From: Marsha Kearney <rmeek1978@gmail.com>
Sent: Monday, August 03, 2020 9:02 PM
To: Richard Stevenson
Cc: p crump; Ron Bohannon; rick@rba81.com; gnh5976@gmail.com; 1garciagang@gmail.com; mdmiraba@msn.com; meganfitz@live.com; bcreel@msn.com; frandimarco@msn.com; cfmirabal@gmail.com; ruffkat@yahoo.com; david.m.lopez@msn.com; garnand_lu@yahoo.com; kmcvey124@comcast.net; tjmurieta@msn.com; nenaperkin@gmail.com; avalgman12@gmail.com; scott.templeton@comcast.net; chavezdyx4@yahoo.com; mccormackdj@comcast.net; erin.coffman@yahoo.com; huerta.loretta58@gmail.com; gayle.binkley@me.com; marshakearney@gmail.com; nauticalhutch@gmail.com; miladybutler@yahoo.com; rfasel@fed.net; Gomez, Angela J.; Wolfenbarger, Jeanne; Gould, Maggie S.
Subject: Re: [#2020013] Wintergreen Apartments DRB questions (PR-2020-004030)

The intent of this email is to provide responses to the questions raised by neighbors at the DRB hearing on July 22nd 2020, in regards to the proposed Wintergreen Apartment project City project number PR-2020-004030.

SECTION 1

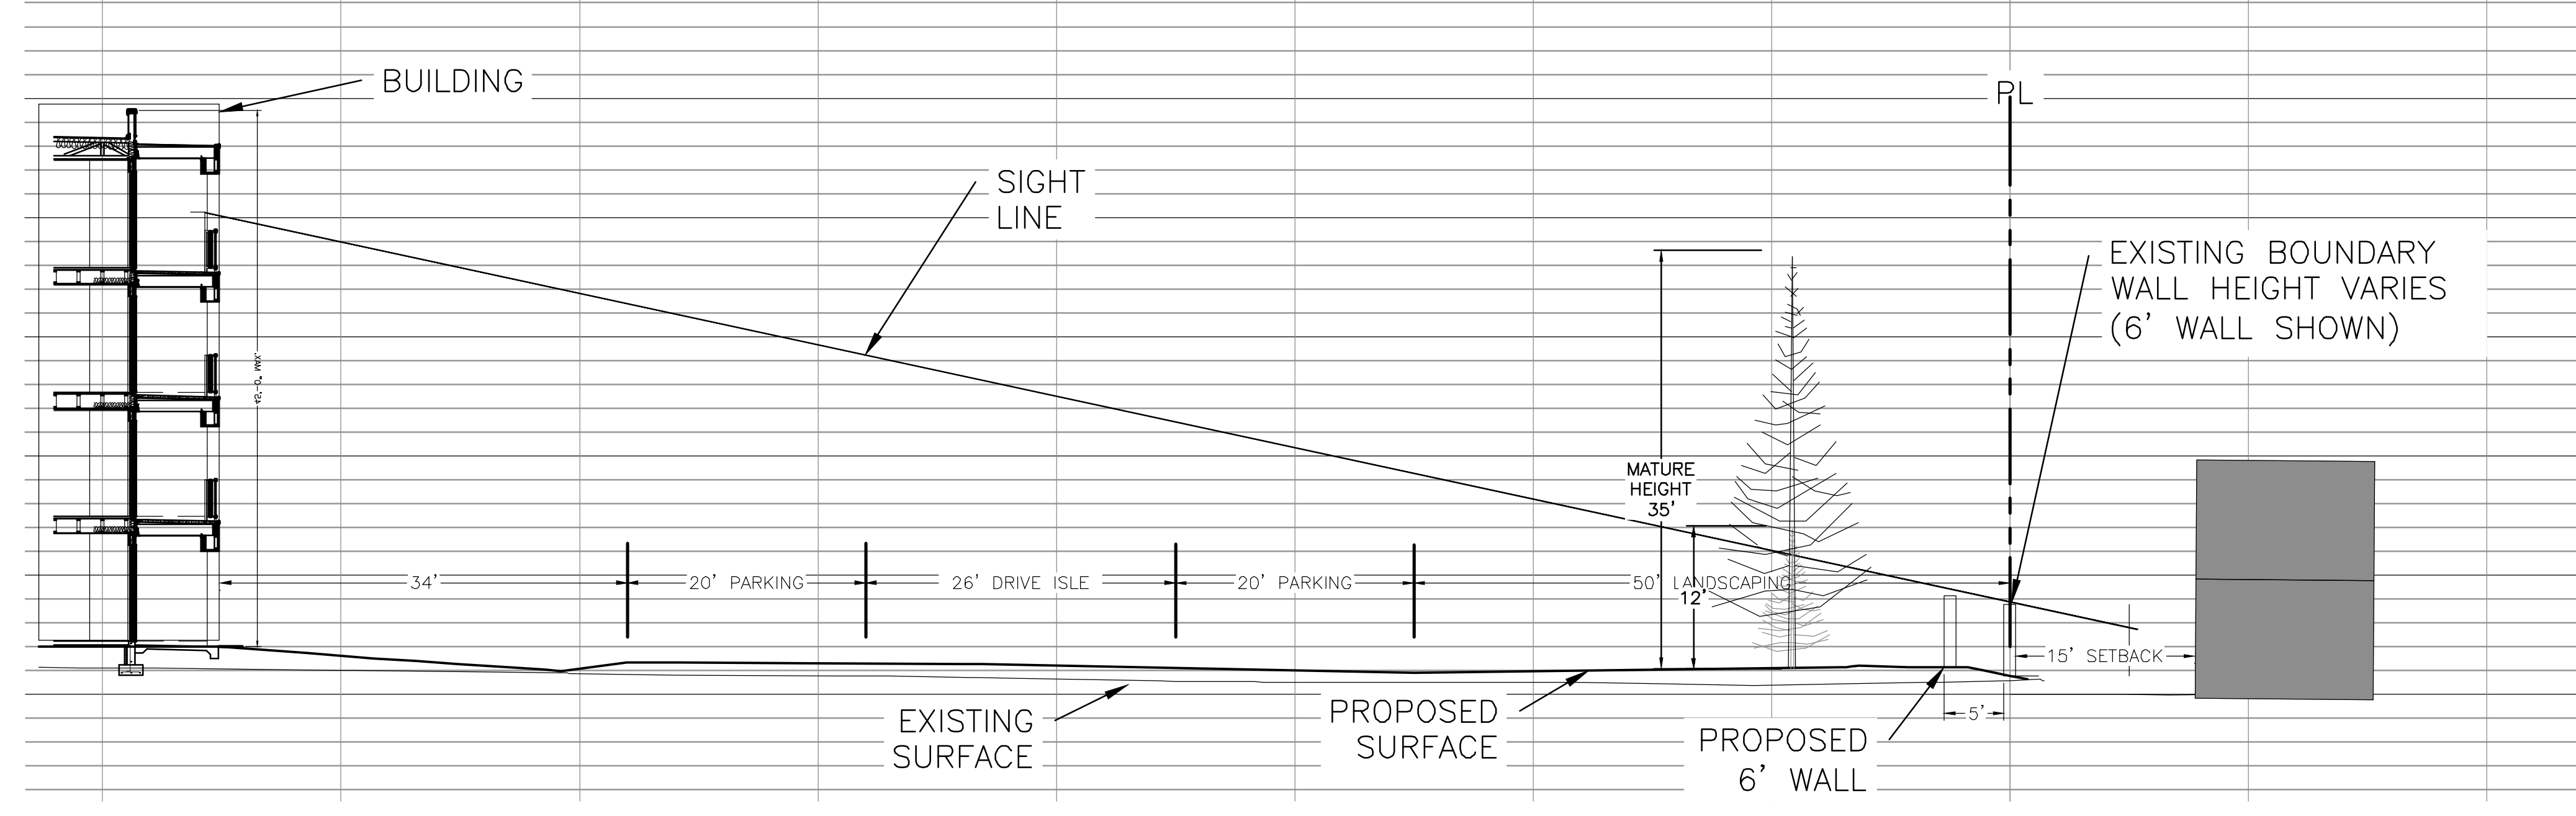
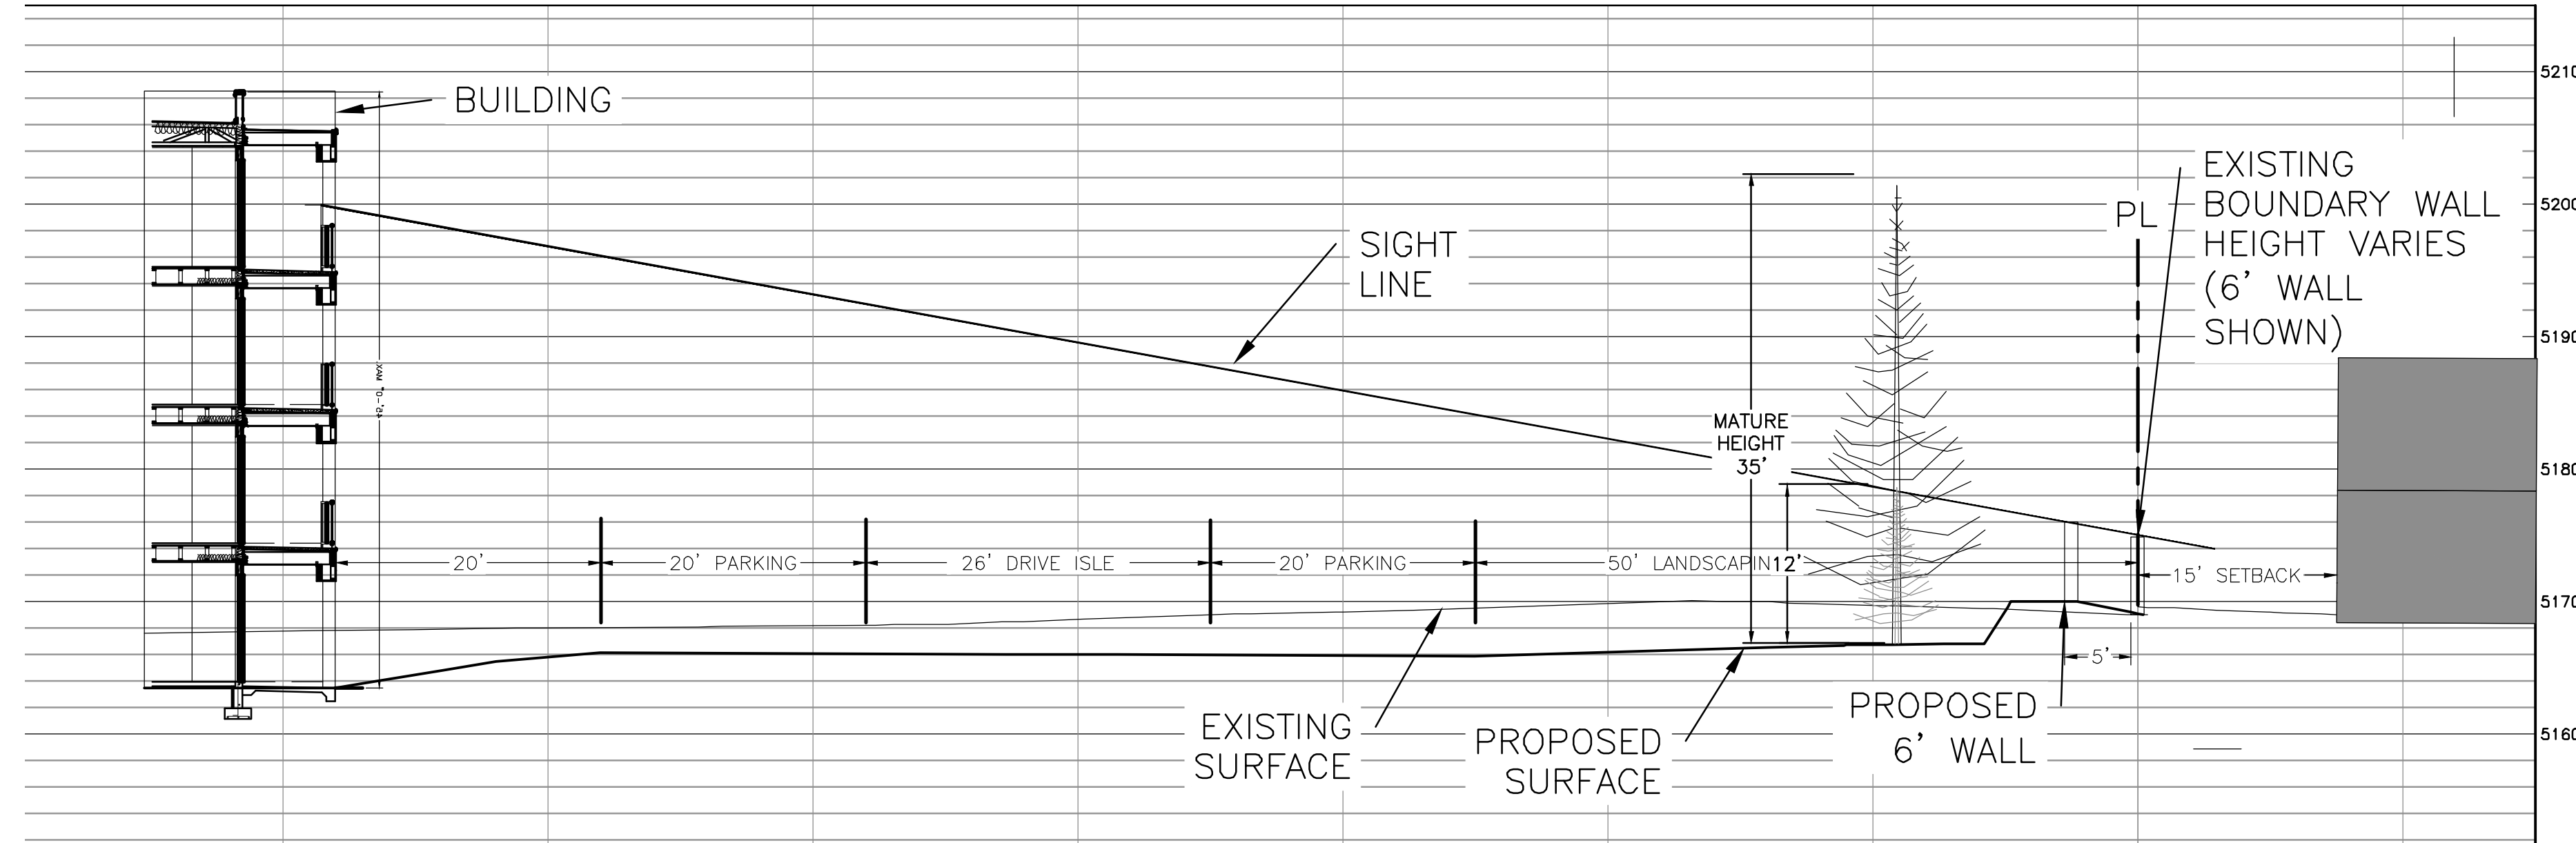
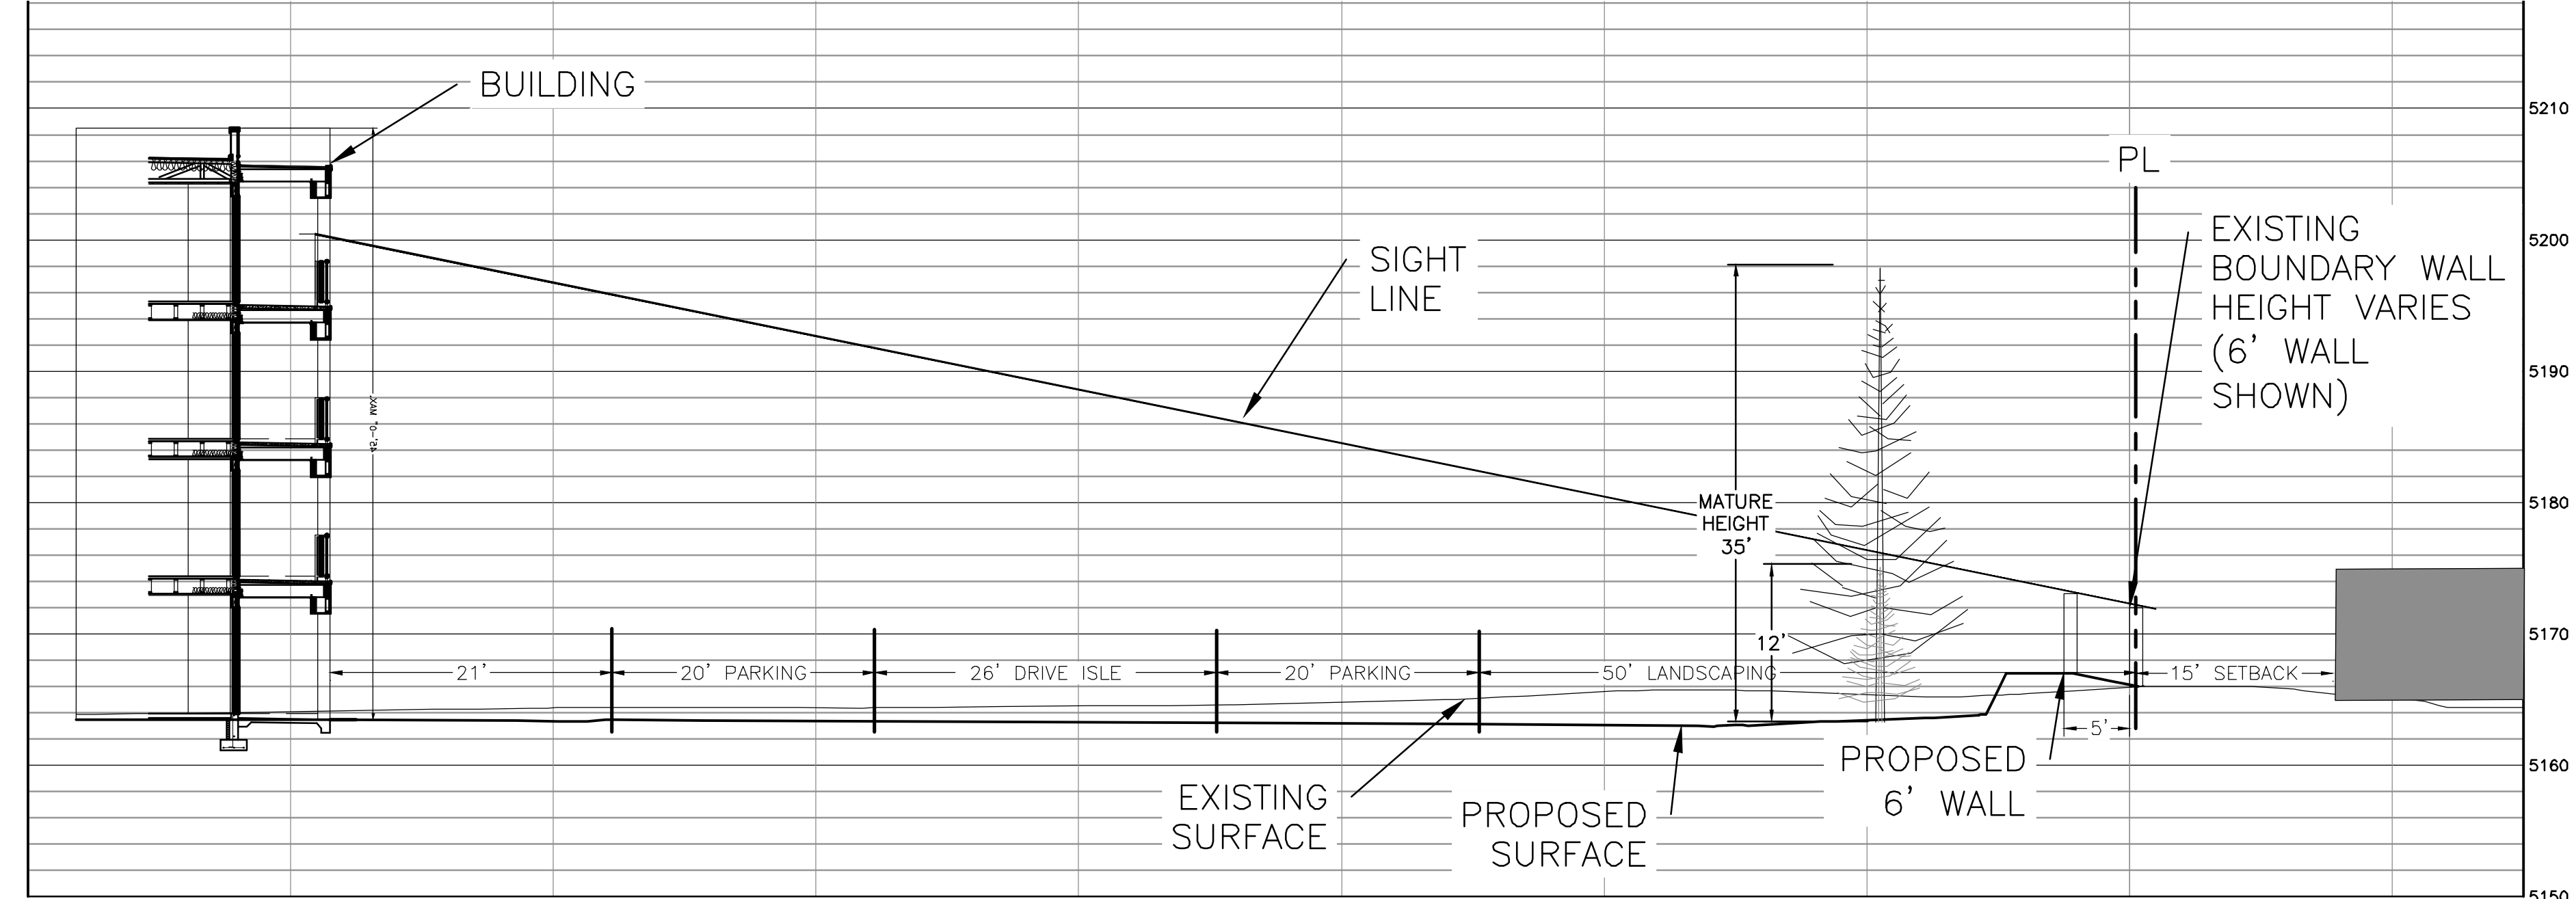
7. The cross-sections provided are inadequate when speaking to the privacy and noise barriers needed for the residents. Cross-sections show trees. Where exactly are they planted, spacing, heights, etc. We have no clear view of what will be in the buffer and how it will protect the adjacent property owners.

Response: A view plan exhibit was prepared to show the sections along the east half of the property and is attached to this email.
